**Consultation Response from KC,
Lead Local Flood Authority**

2024/92576 site of, Former Spotted Cow Pub, New Hey Road, Oakes, Huddersfield, HD3 4BU

Discharge of details reserved by conditions 3 (CMP), 21 (retaining walls), 23 (surface water) and 28 (non-native species) of previous permission 2021/94029 for demolition of existing structures and erection of foodstore (class E) with associated access, parking, servicing areas and landscaping

Condition 23 – Attenuation

TYPICAL ATTENUATION TANK PLAN

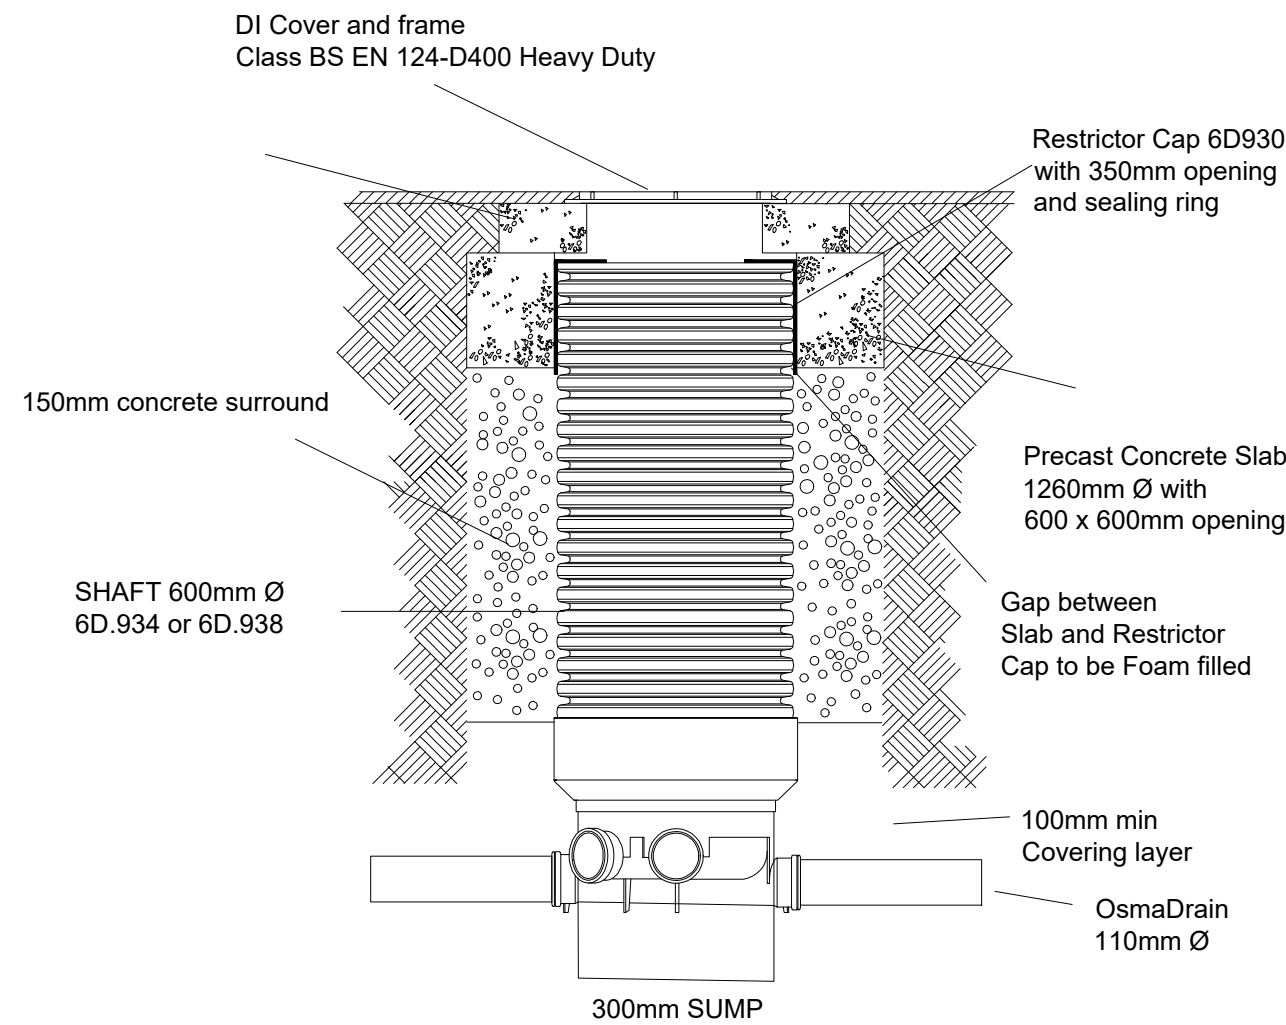
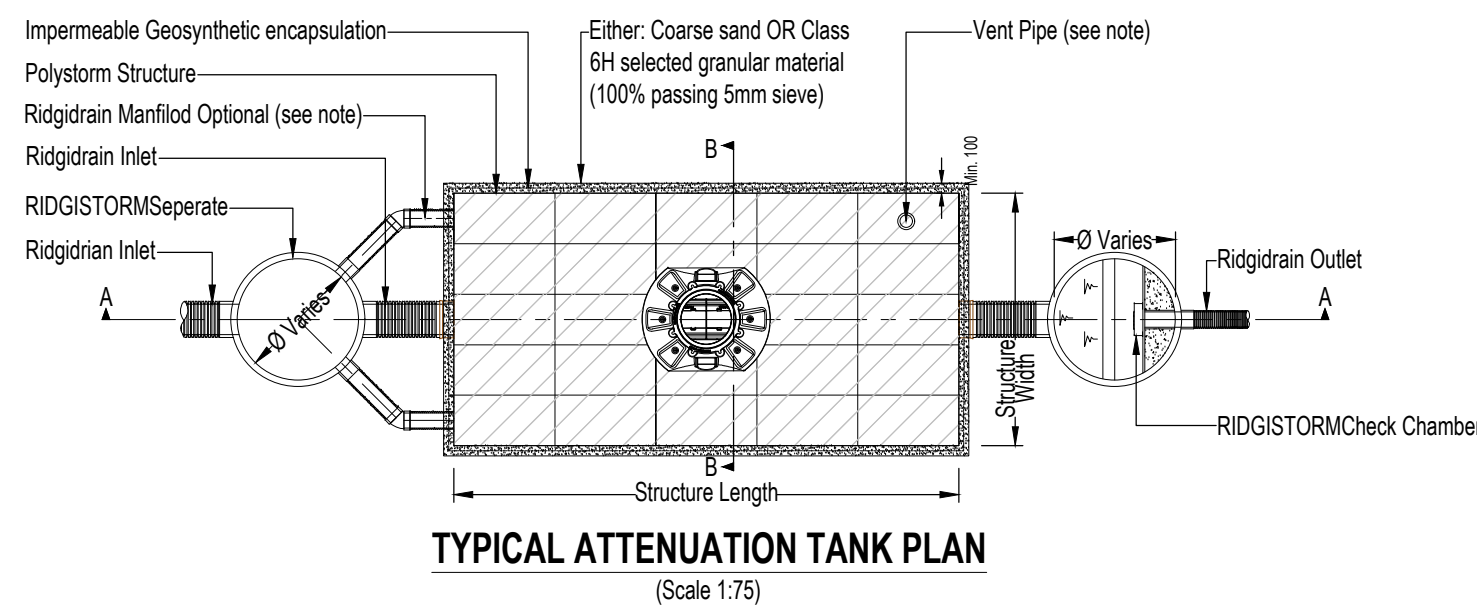
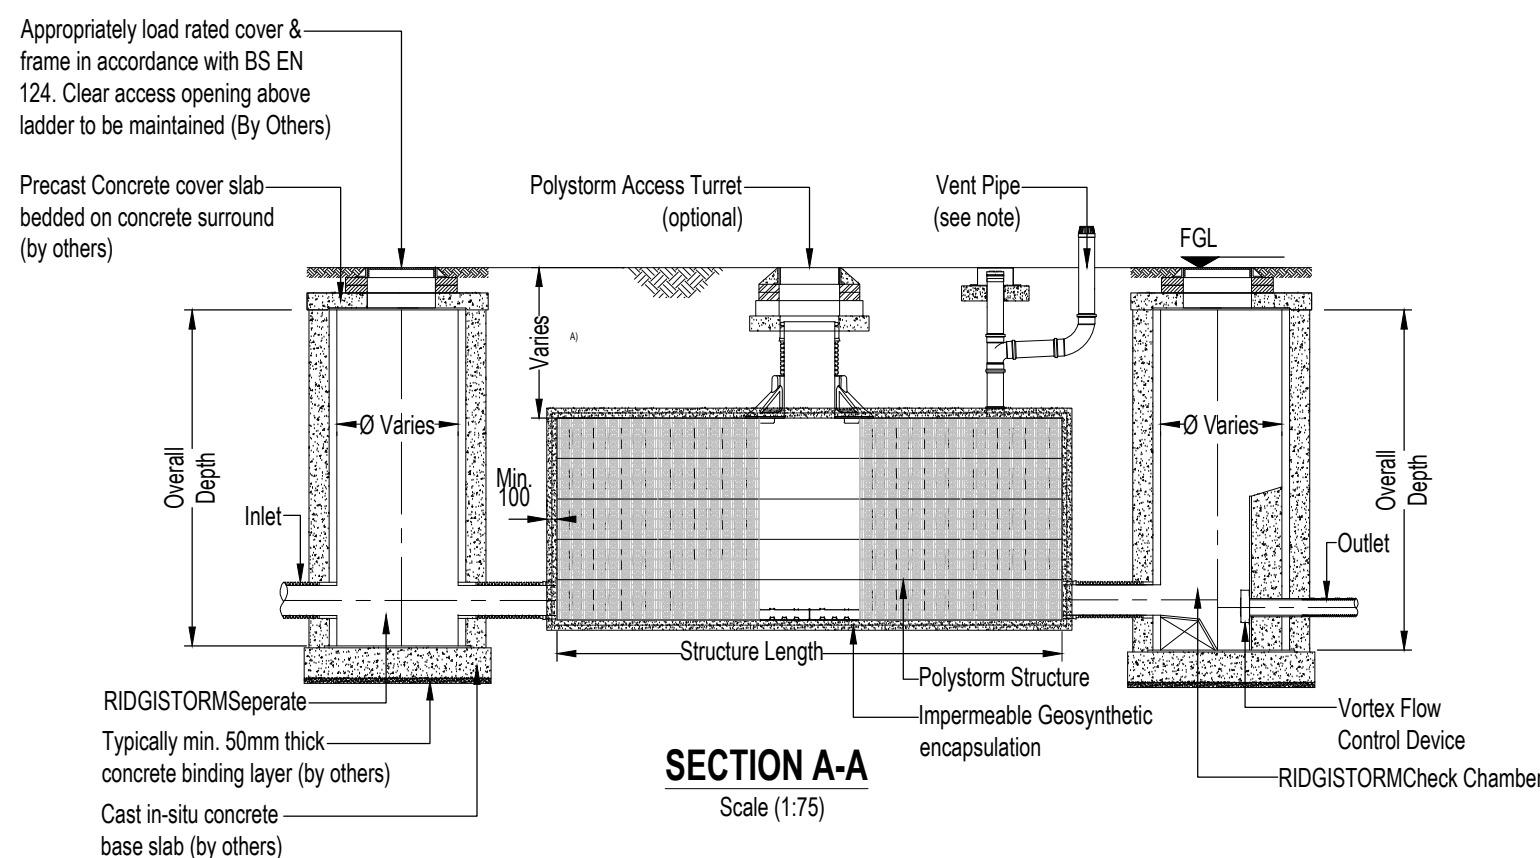
Drainage drawings are still shown as indicative, and the crate storage names a particular product or similar. A final decision needs to be made on the drainage design including selected attenuation tank for comment.

If Polystorm 'R' is selected, we would require a brief assessment as to the recommended depth to invert and depth to cover and how this complies with BBA and manufacturers recommendations. In addition, it is expected that Heavy Goods Vehicles will unload at the site and again, a brief assessment on compliance should be submitted by a suitably experience practitioner.

The drainage drawings show two potential tank locations and one flow control. It is not clear how the southern detention tank is connected to the surface water system either online or offline. The drawing should clearly show maintenance invert levels of the tanks, soffit levels of the storage element and cover levels of any maintenance/observation access shafts. It should also clearly label on the drawing a catchpit manhole and design.

## APPENDIX A – DRAINAGE DRAWINGS

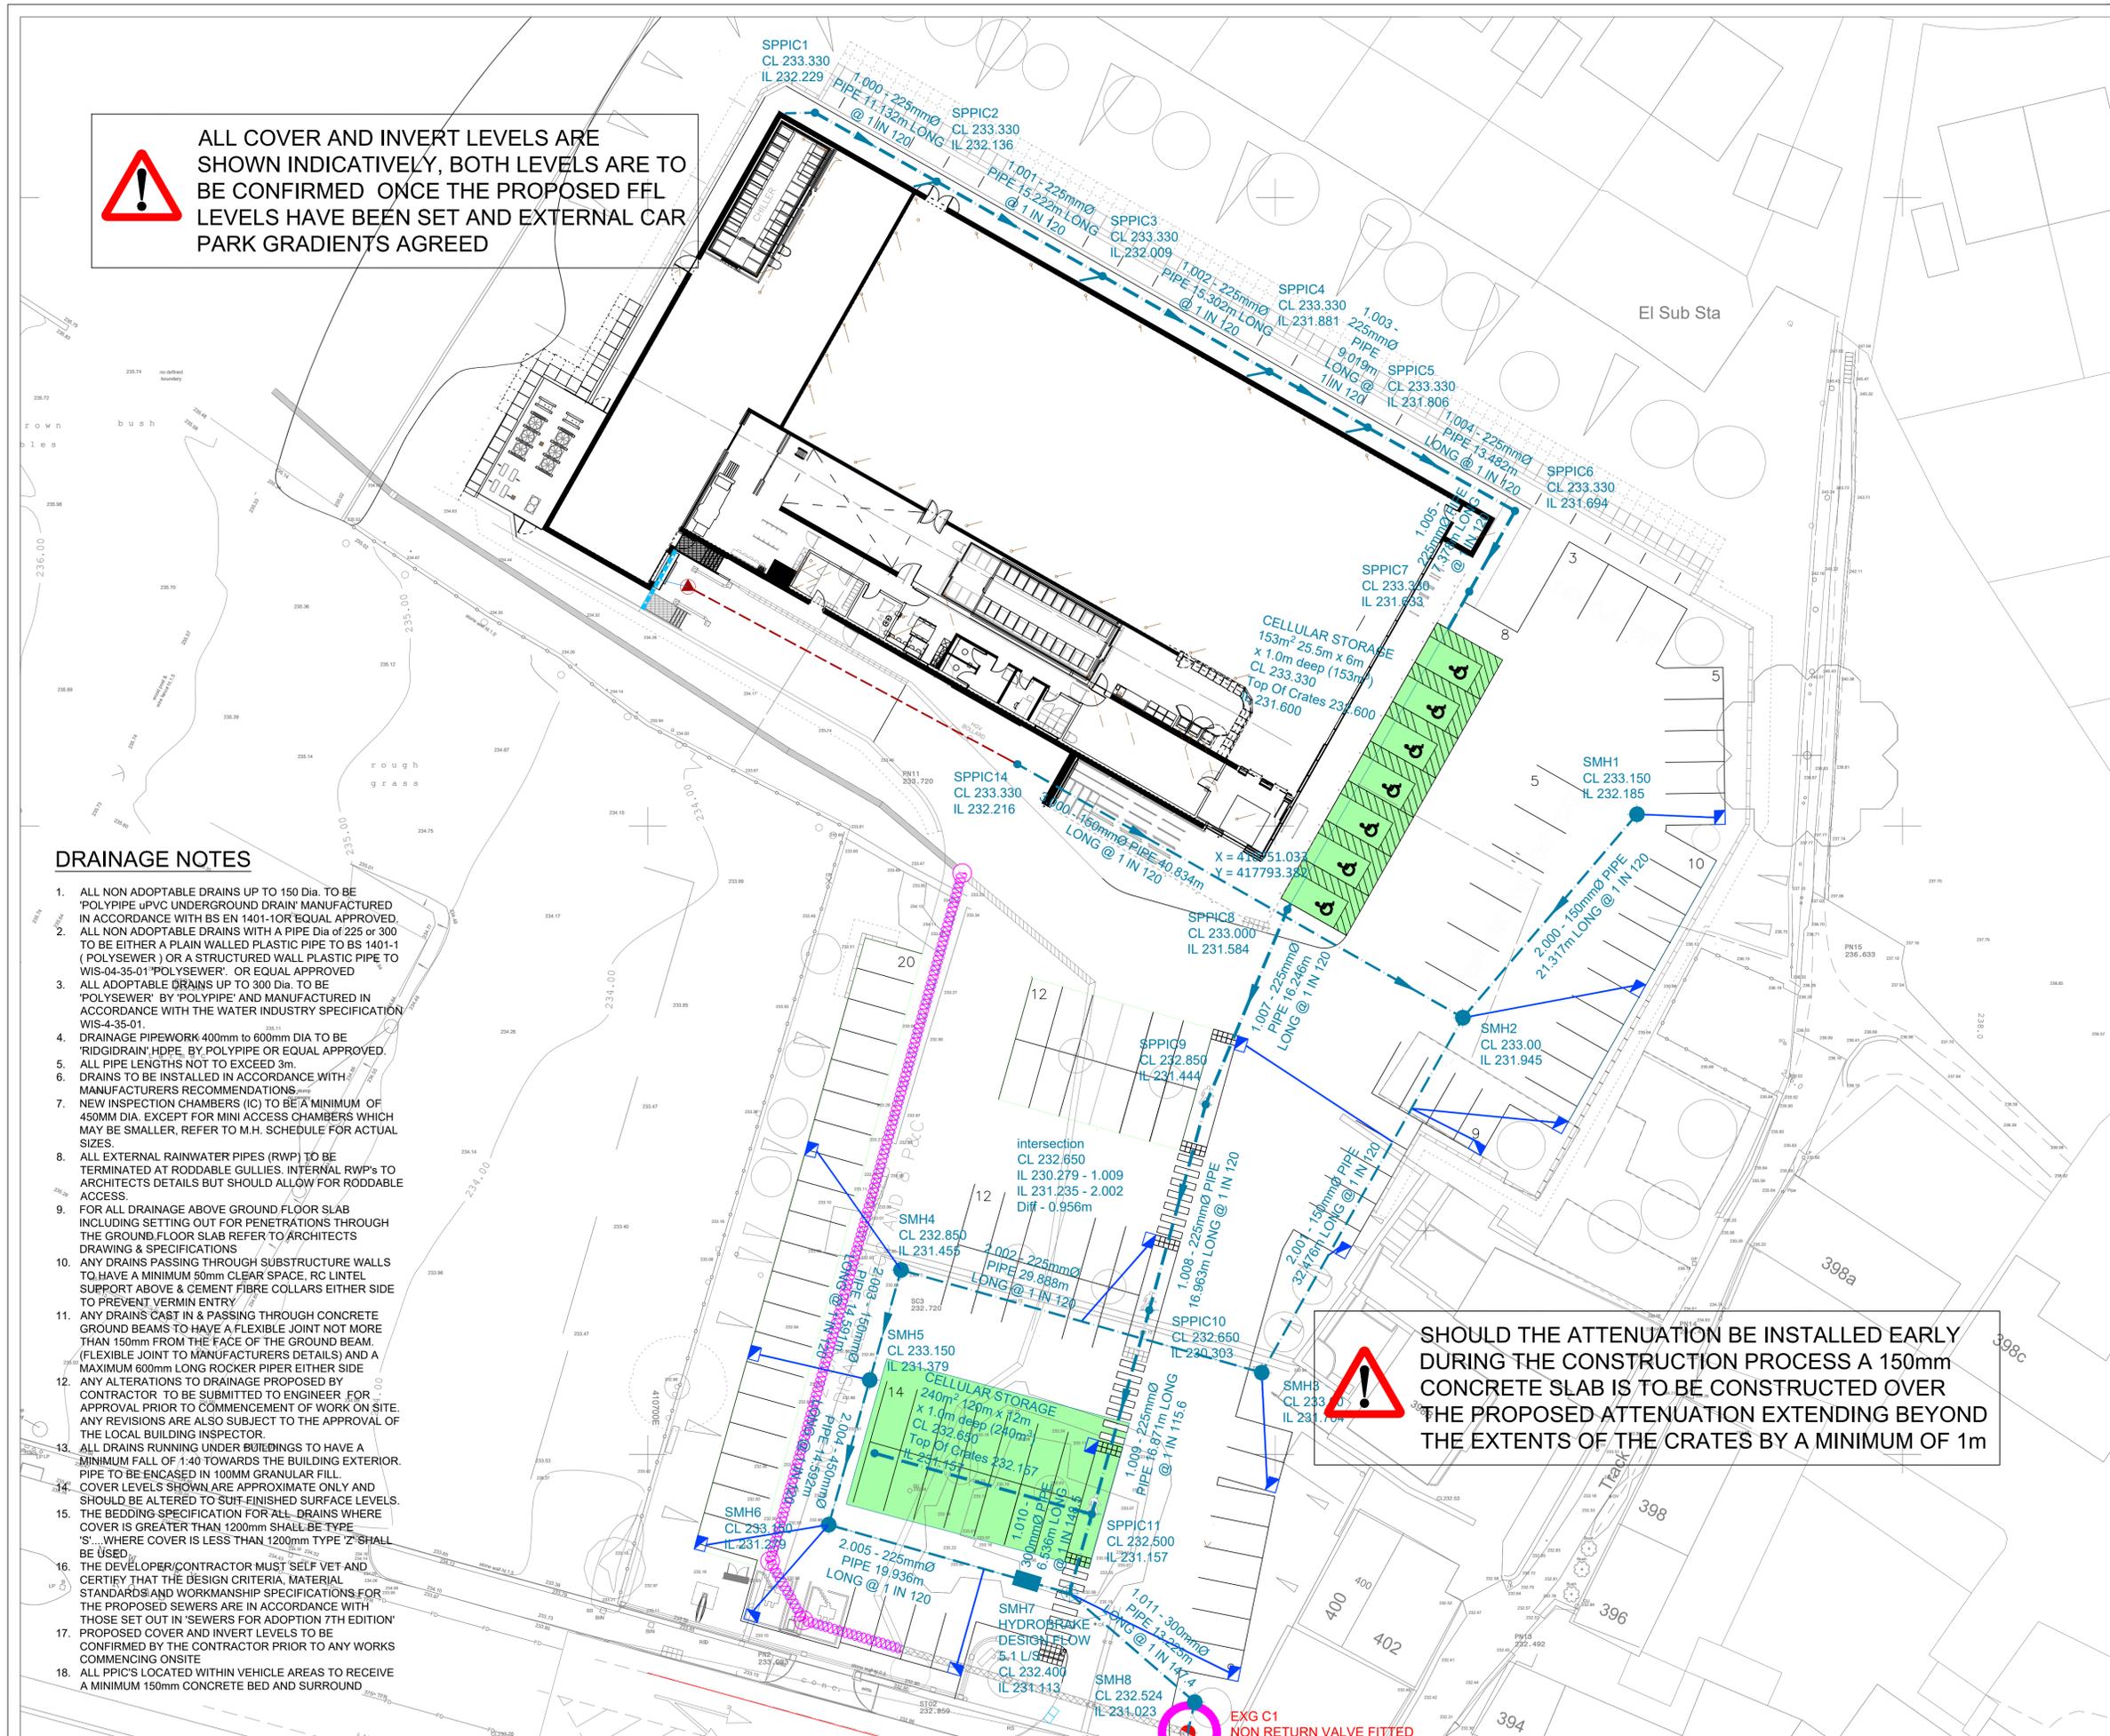
Up to date hydraulic design and simulation models must match the layouts submitted and clearly show where tanks are involved (preferably online for serviceability).
